DRB Application No.: 03-01431 (FP)
Project Name: UNSER CLIFFS SUBDIVISION
Agent: WILSON & COMPANY

5. Project # 1002503
03DRB-01268 Major-Preliminary Plat Approval

**CITY OF ALBUQUERQUE
PLANNING DEPARTMENT
Development Review Board
September 3, 2003 Comments**

RE: Unser Cliffs Subdivision/Plat

PRELIMINARY PLAT
FOR
Blocks 1-5
UNSER CLIFFS SUBDIVISION
WITHIN SECTIONS 22 & 27
T.11N., R.2E., N.M.P.M.
CITY OF ALBUQUERQUE
BERNALILLO COUNTY, NEW MEXICO
JUNE 2003

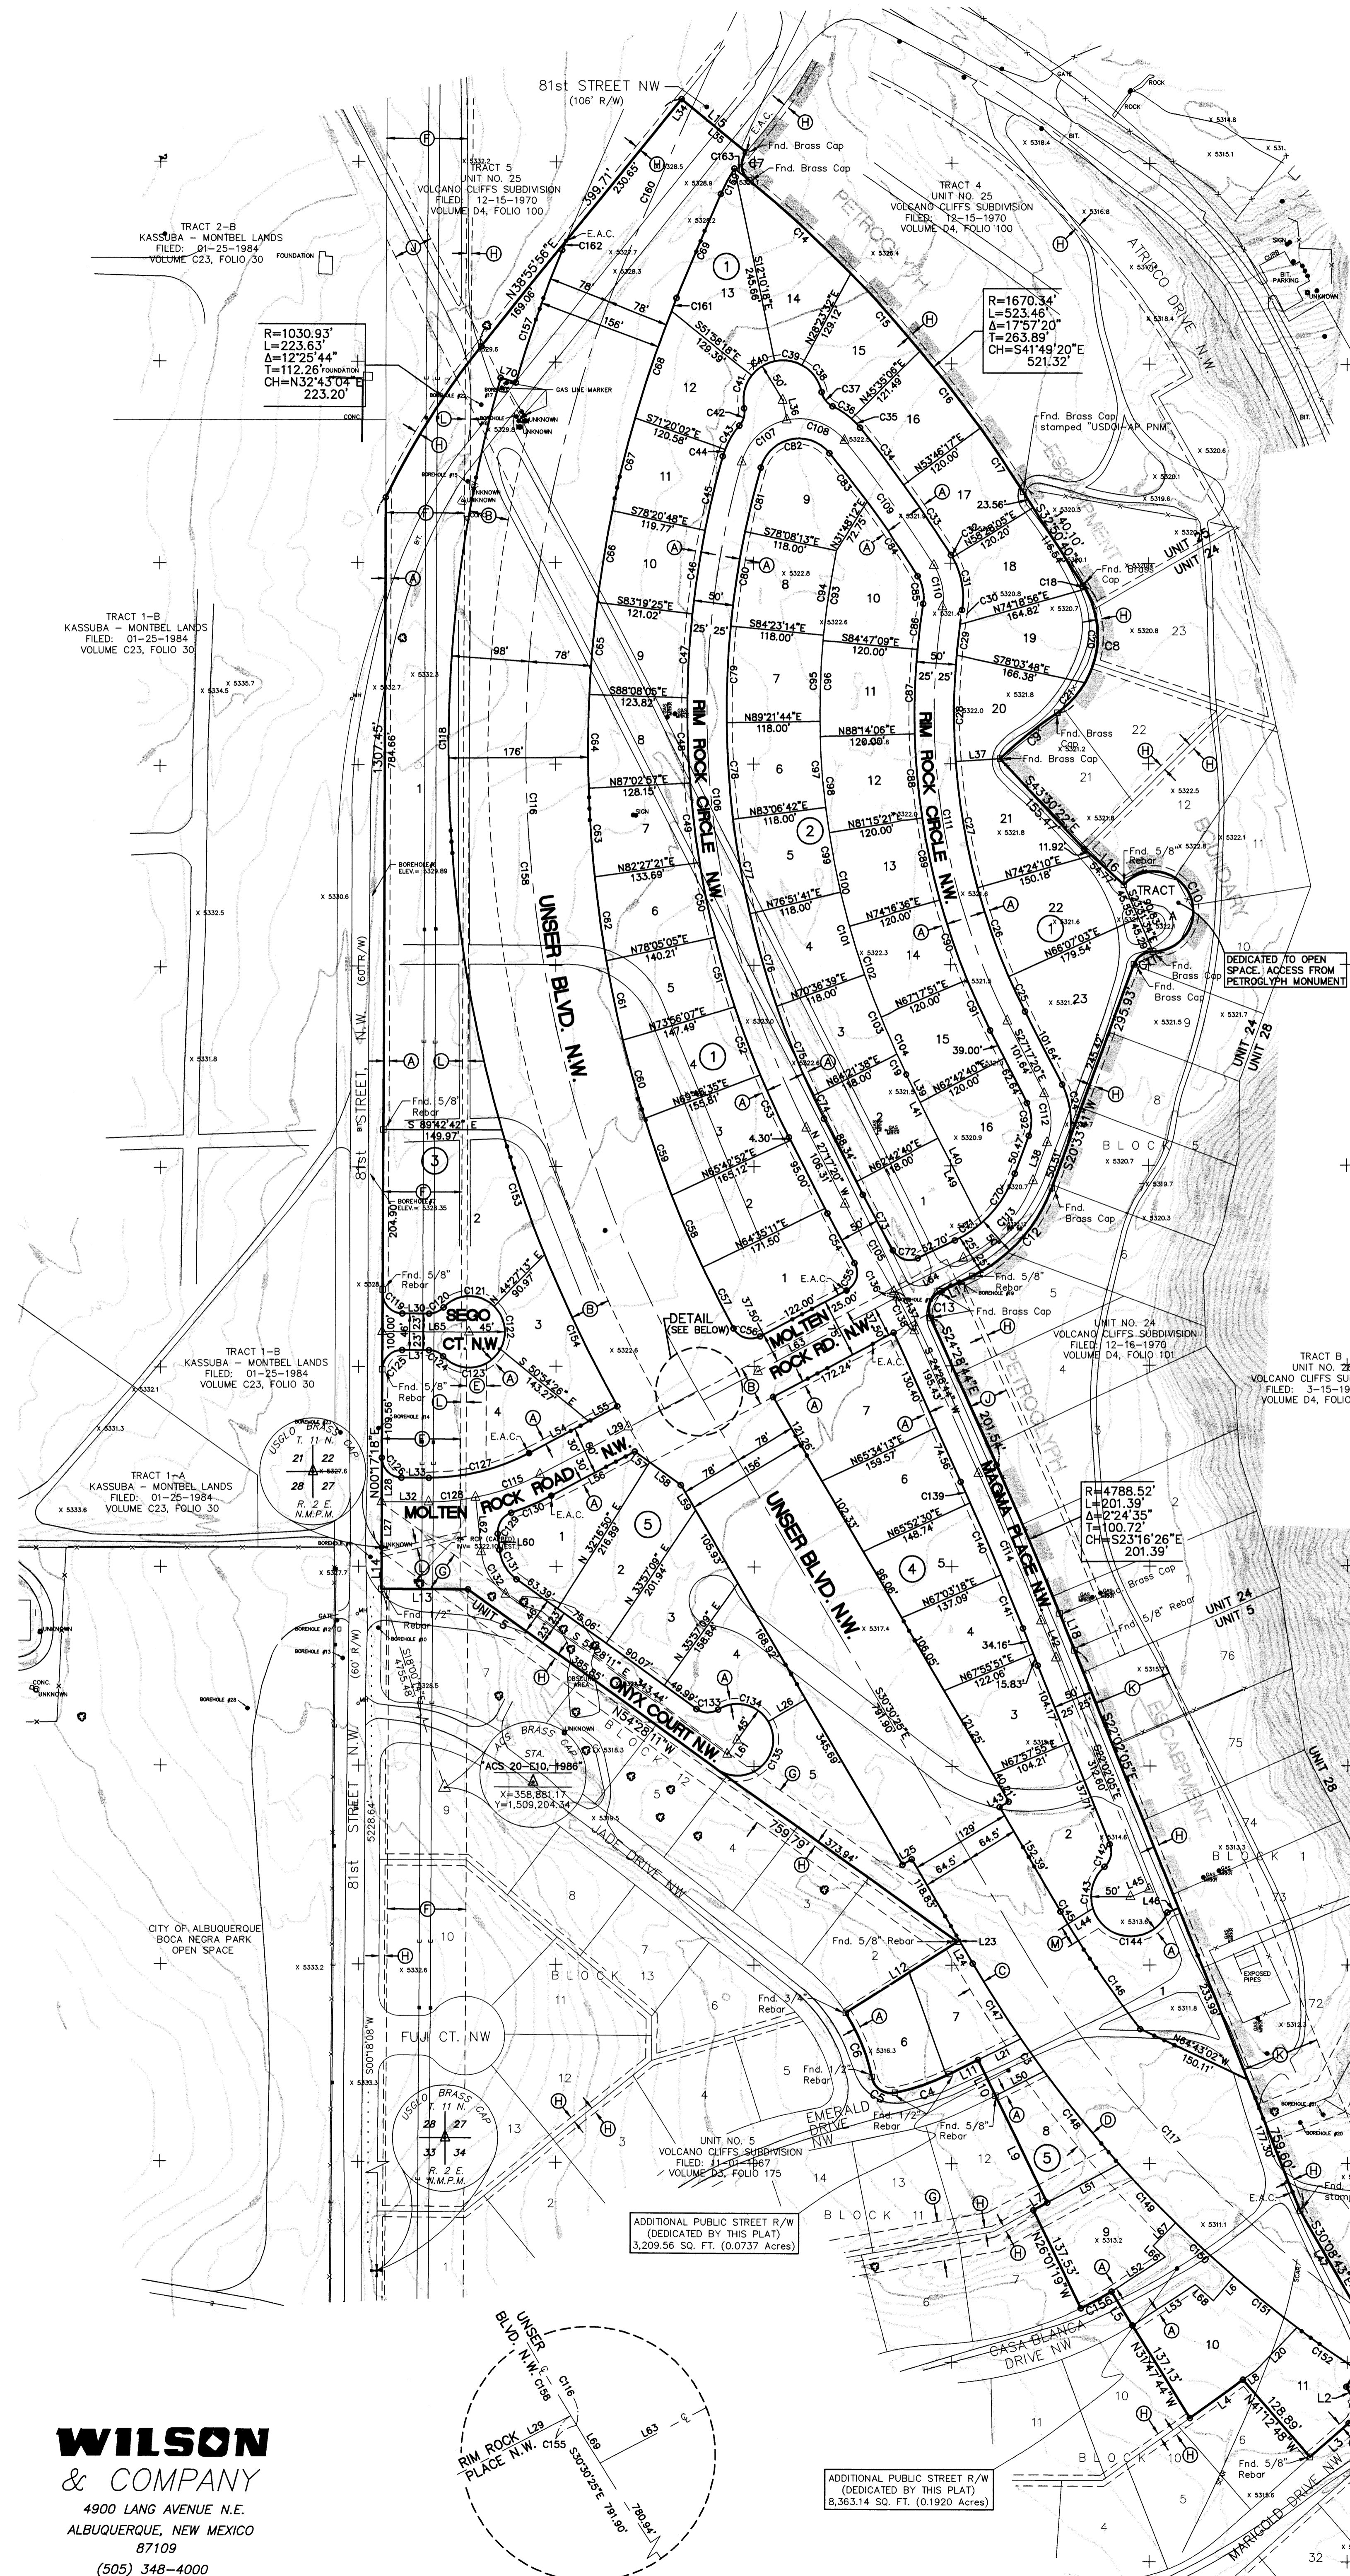
Fire Department Fire Department is not approving street widths less than 32 feet at this time. Per Ray Sanchez, AFD.
All required fire hydrants shall be installed and made serviceable prior to and during construction of subdivision.

Does PNM maintain the easement between 81st St. and Unser? Have the number of lots decreased since the last recorded plat? Defer to transportation regarding the alignment of Unser and the newly created lots adjacent to Unser.

The Purpose of the Plat must be stated on the preliminary plat as well as the final plat. The size of the lots are also required on the preliminary plat.
